WEST SUSSEX COUNTY COUNCIL CONSULTATION

TO:	Arun District Council FAO: Michael Eastham
FROM:	WSCC - Highway Authority
DATE:	17 December 2021
LOCATION:	Central Wetland Area Hampton Park Toddington Lane Littlehampton BN17 7PL
SUBJECT:	LU/369/21/RES Approval of reserved matters following outline consent LU/47/11/ (amended under LU/182/15/PL) for the main on-site infrastructure at Hampton Park and encompasses: 1) the Central Wetland Area, 2) the main spine road and crossing structures & 3) the SUDs features.
DATE OF SITE VISIT:	n/a (desktop study undertaken)
RECOMMENDATION:	More Information Required
S106 CONTRIBUTION TOTAL:	n/a (SEE S106 AGREEMENT FOR OUTLINE CONSENT)

This is the WSCC County Highways (CHA) response to the above planning application for approval of reserved matters following outline consent LU/47/11/ (amended under LU/182/15/PL) for the main on-site infrastructure at Hampton Park and encompasses: 1) the Central Wetland Area, 2) the main spine road and crossing structures & 3) the SUDs features.

Client					
Date of 1st Issue	07.08.2018	Designed	JWS	Drawn	CRD
At Scale	AS SHOWN	Checked	JWS	Approved	JWS
Drawing Number	35944/1507/010		P01

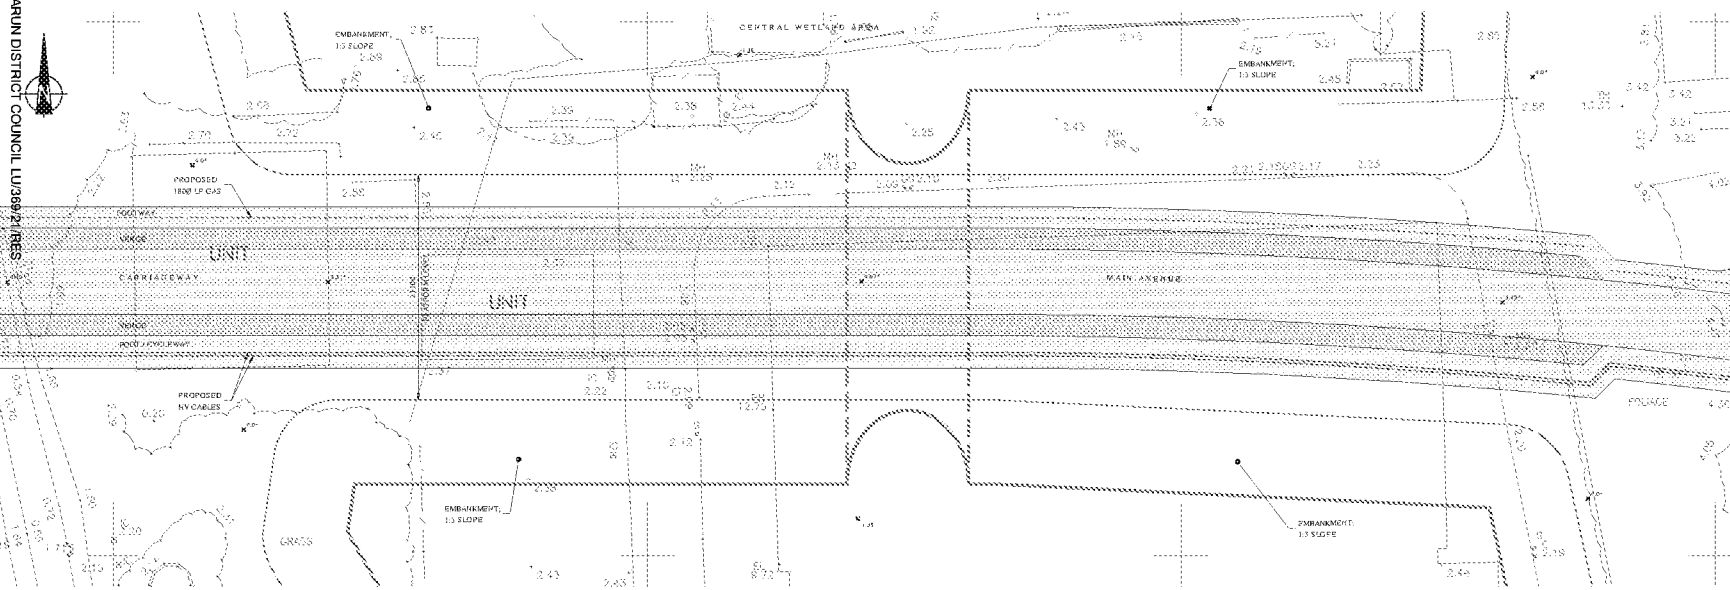
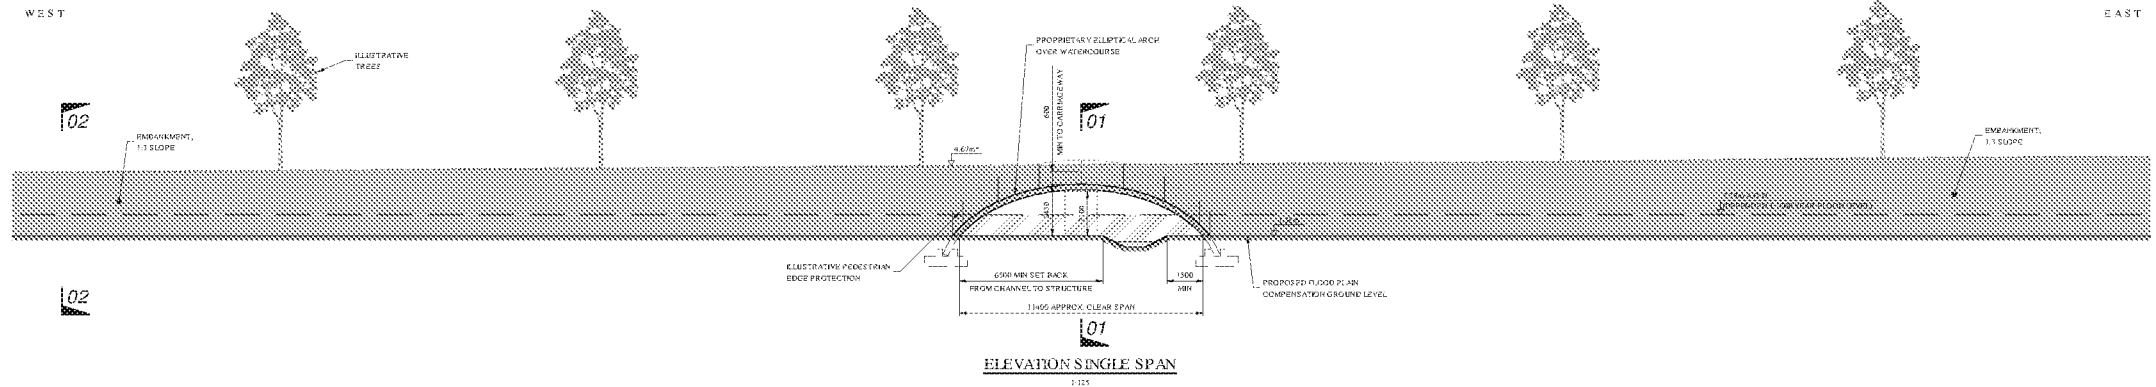
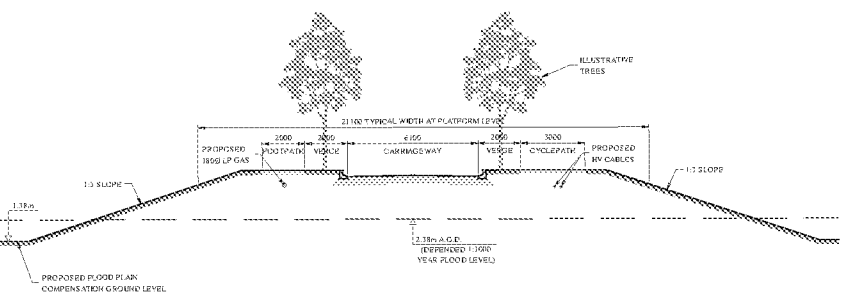
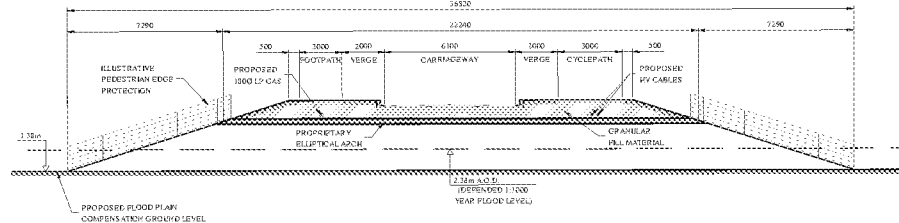
1. Spine road (first section as described above) – It is unclear from the drawings as to the extent of road requiring consideration, particularly as the red edging seems to

extend around the whole spine road. However, considering the first section of road shown on the drawings running over the northern 'bridge', it appears to follow a predominantly straight alignment although this curves slightly southwards east of the proposed 'BeBo' arch. It also appears to have slight gradients on both approaches although this isn't wholly clear from the drawings. A carriageway 'narrowing' appears to be shown centrally on the road crossing the 'bridge'.

In order for the CHA to consider the design further, a short design check using DMRB and LTN 1/20 and a Stage 1 Road Safety Audit (and Designer's Response) should be provided.

Pile Cap - Plan View
Scale 1:100

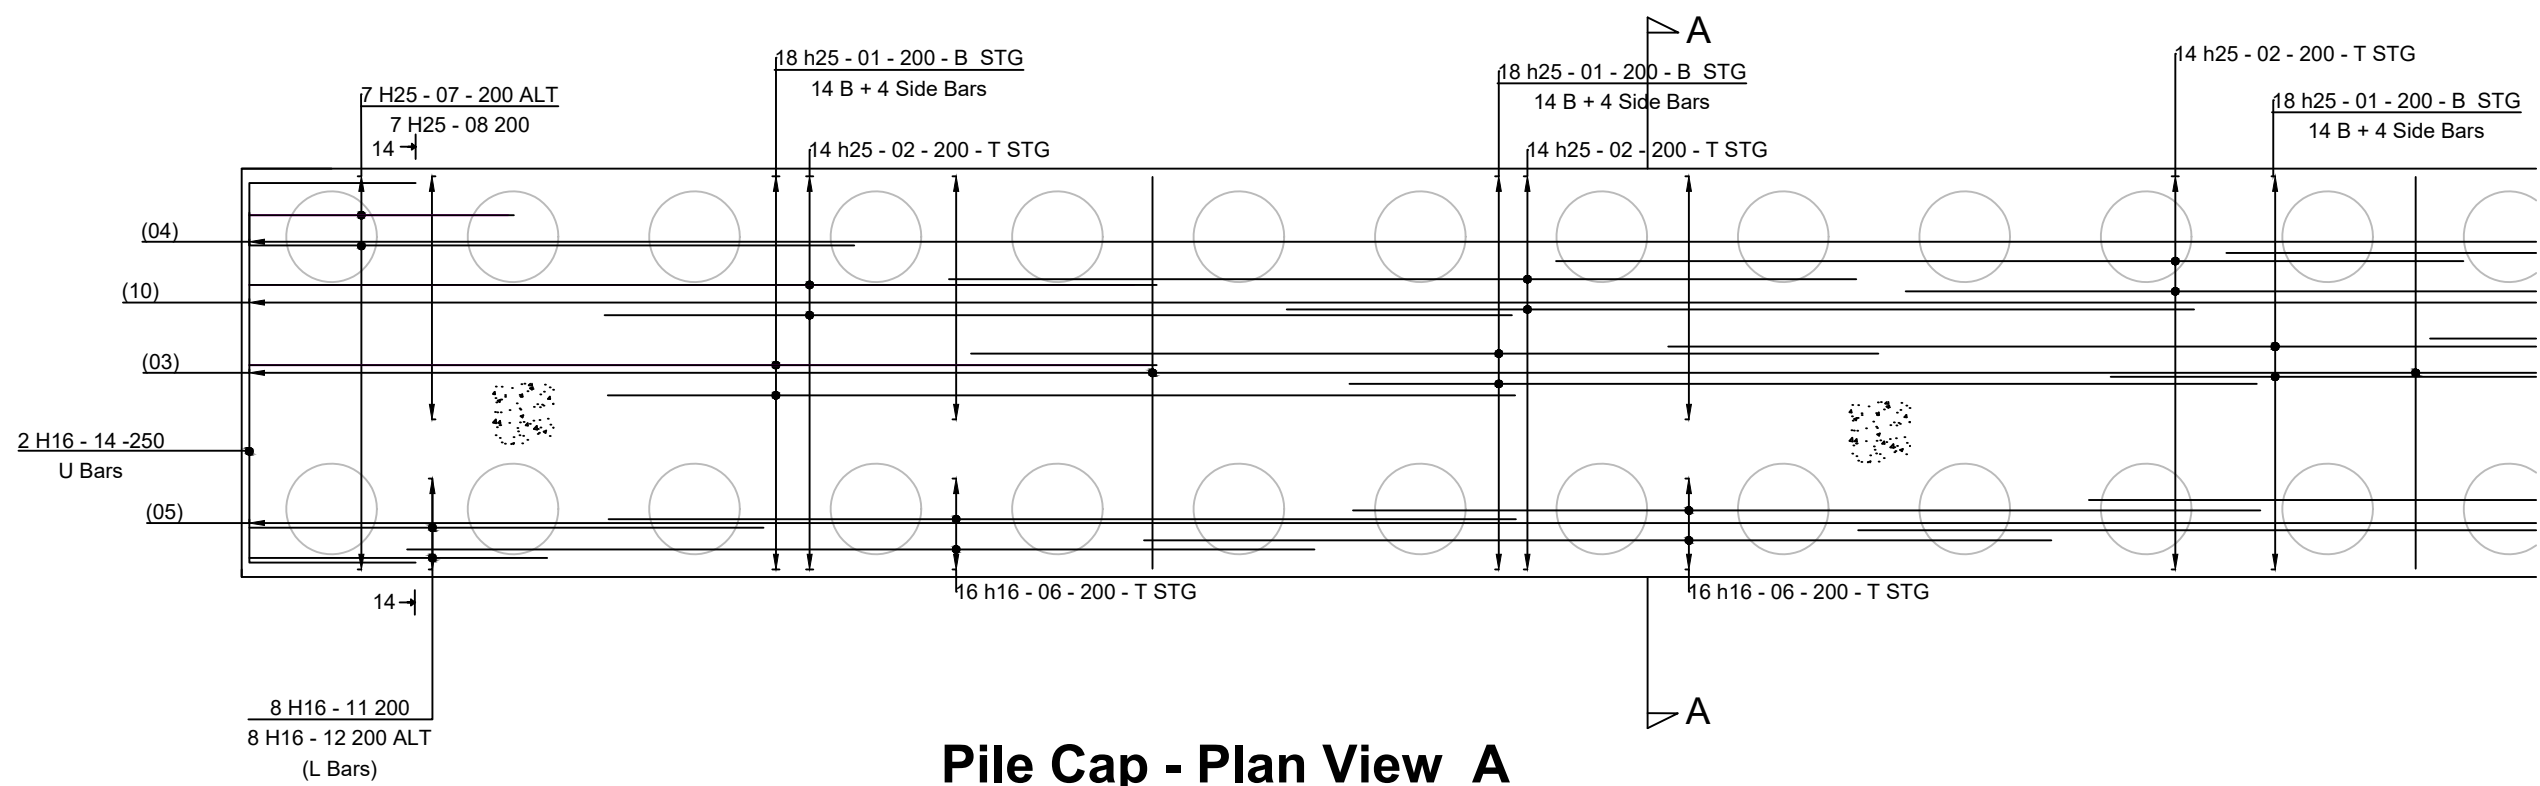
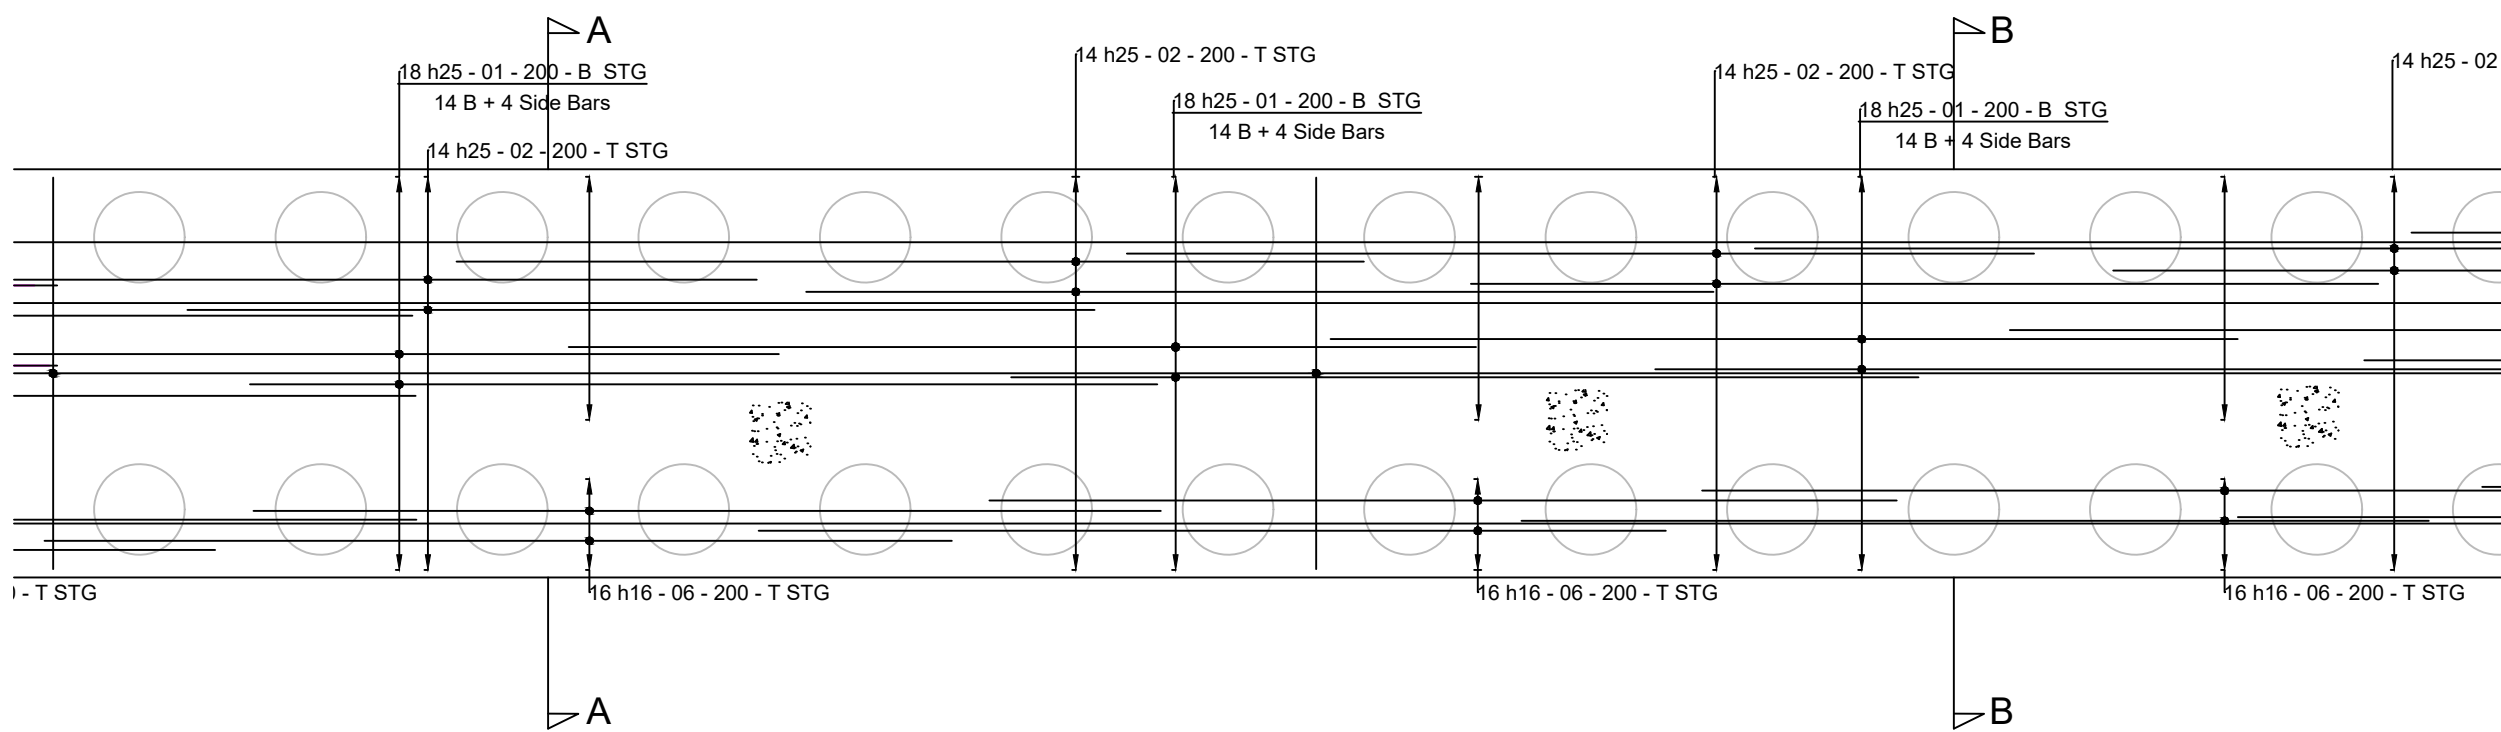
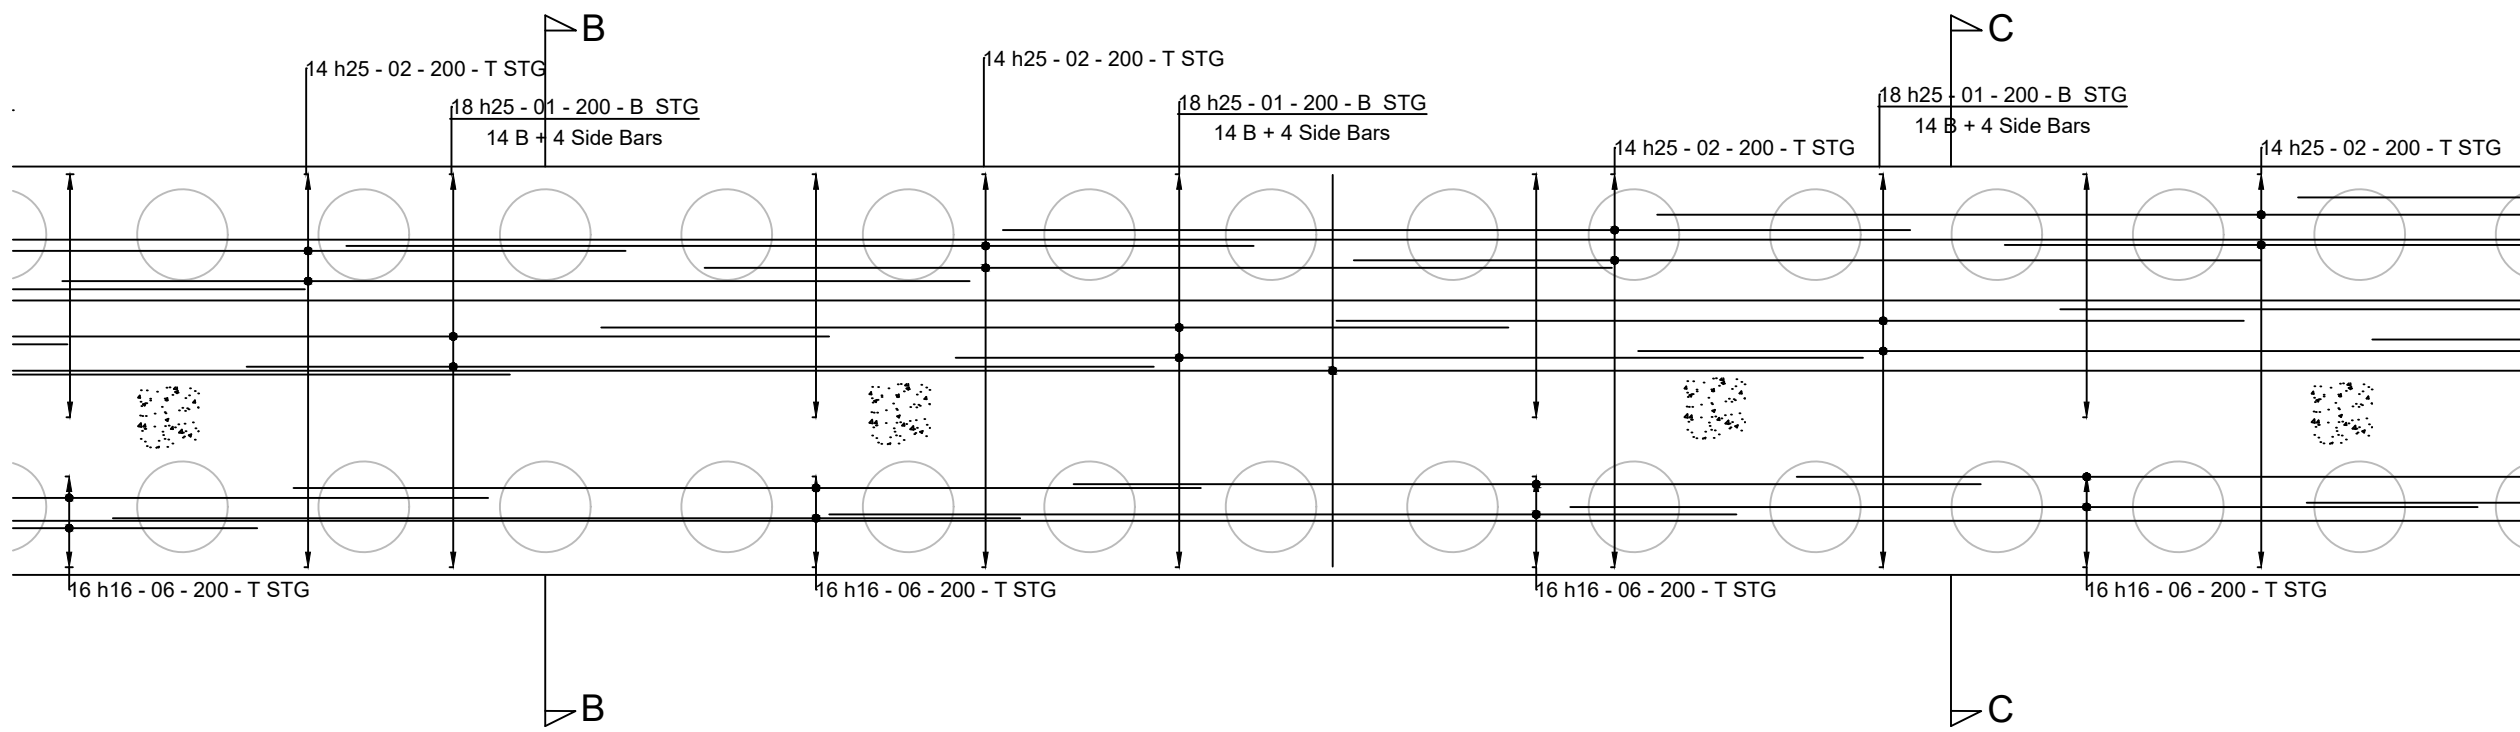
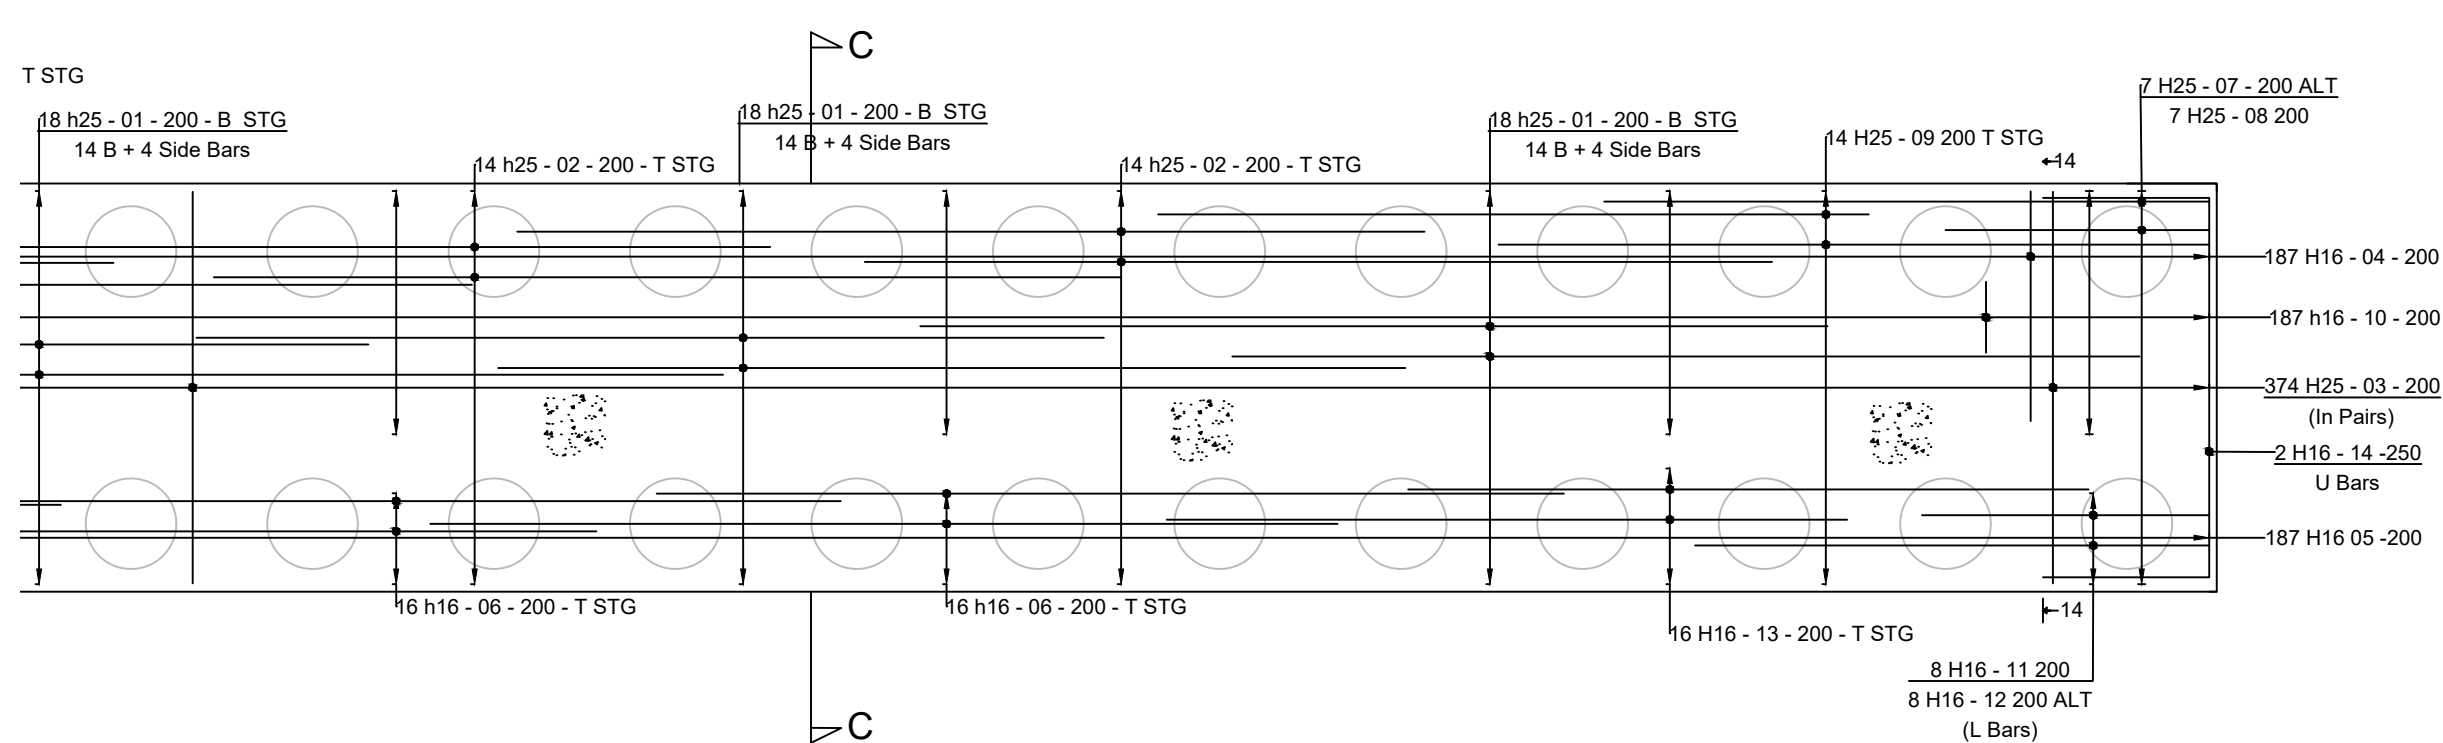
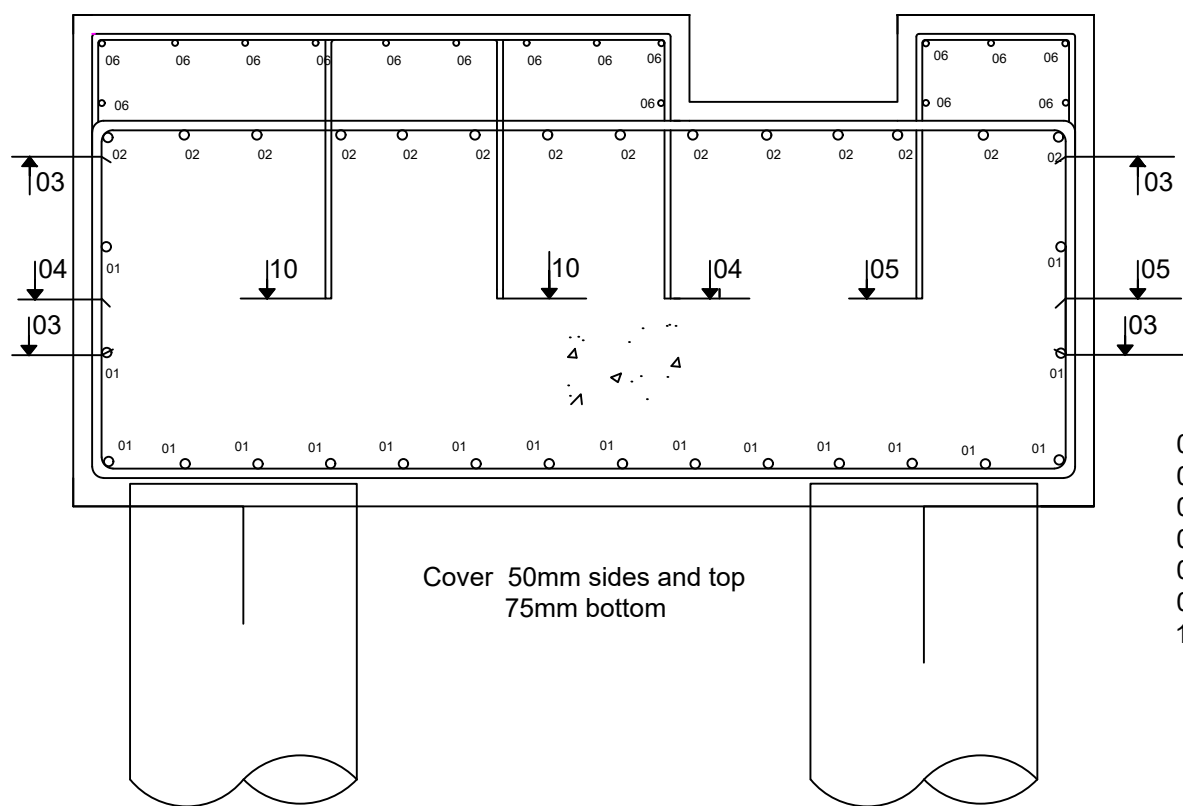
2. There's a drg. for the piles and piles caps (drg. 2231-001 & 002) that WSCC hasn't seen previously but wouldn't expect to see until the awaited Design and Check submission (which will also require approval) prior to construction.
